23/10280

Application for removal or variation of a condition following grant of planning permission.
Town and Country Planning Act 1990.
Planning (Listed Buildings and Conservation Areas) Act 1990

1.	Condition 1 of Reserved Matters approval ref. 18/10801	6.	
2.		7.	
3.		8.	
4.		9.	
5.		10.

SHEET  
**Proposed Landscape Plan**

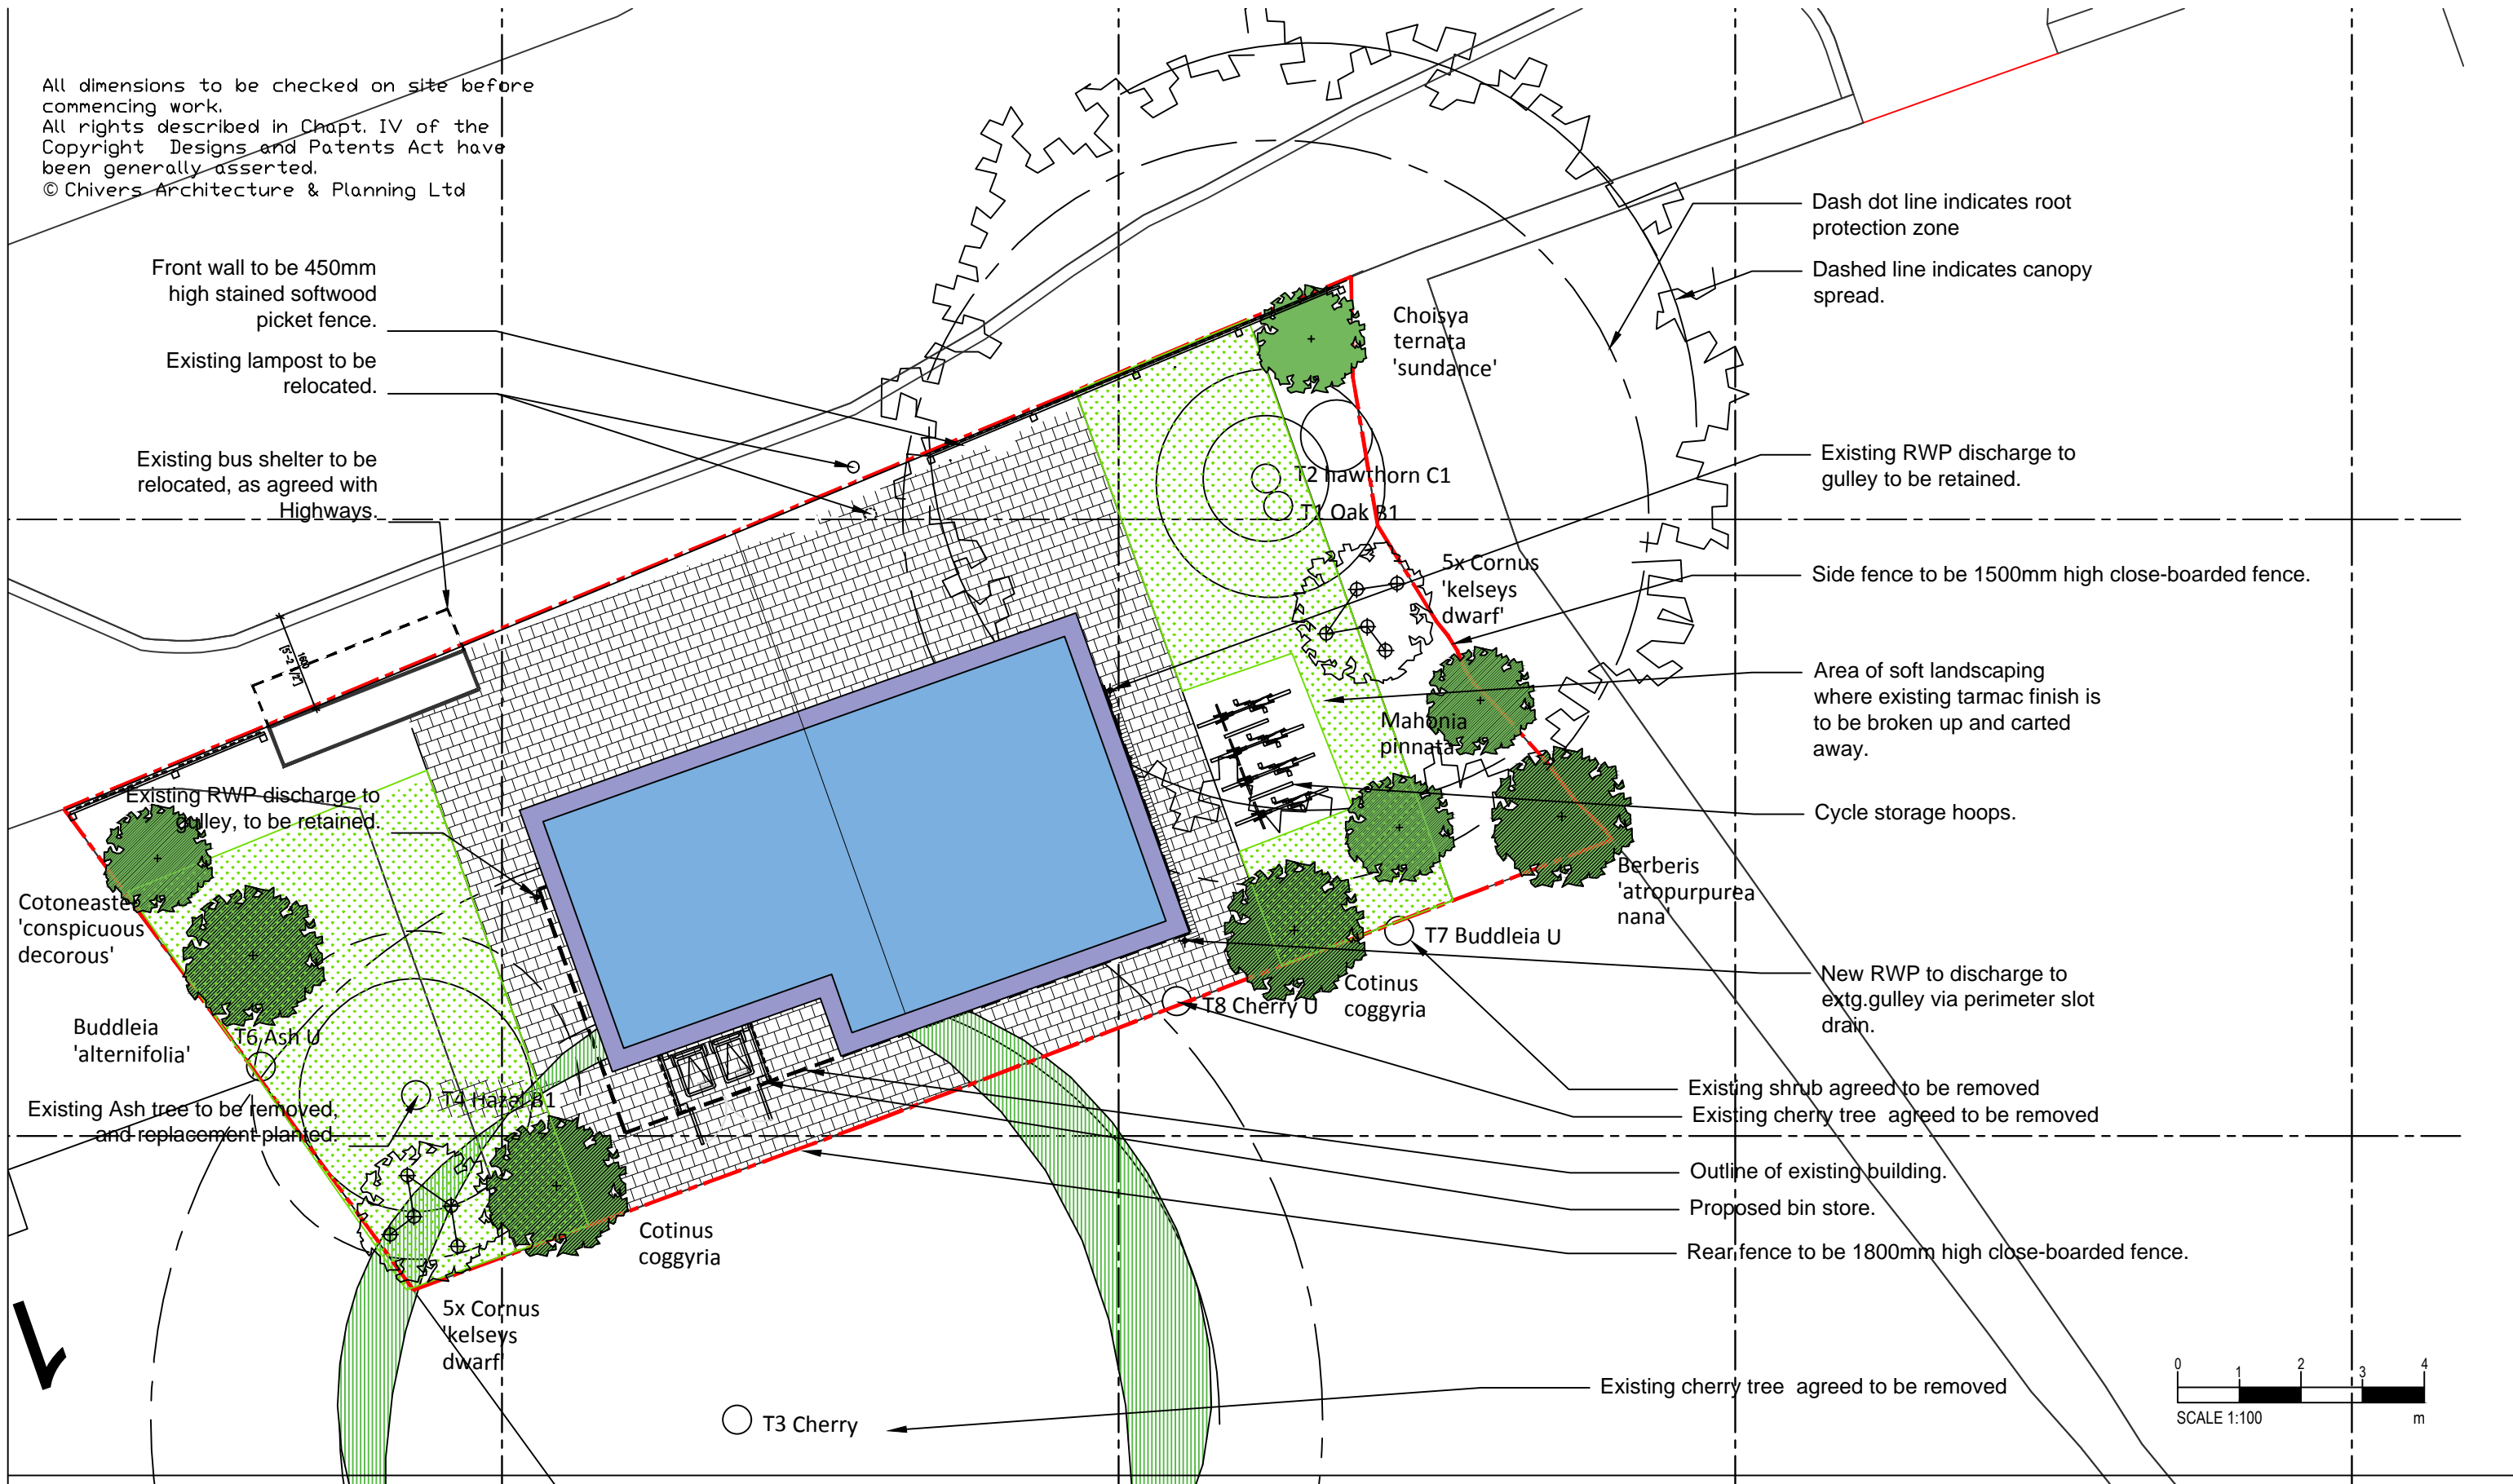
Front (NW) elevation variances with the window / door openings.
 Rear (SE) elevation a first floor window is missing.
 Can you also confirm the building is correctly positioned on the plot.
 Can you also advise where the detail of the new bus stop is shown.

Building Control requirement to maintain corner strength.
 Internal space requirements to allow wall shelving for office.
 The setting out point is correct.
 It is shown in the front NE corner on Site Plan 1614/A103/C attached.
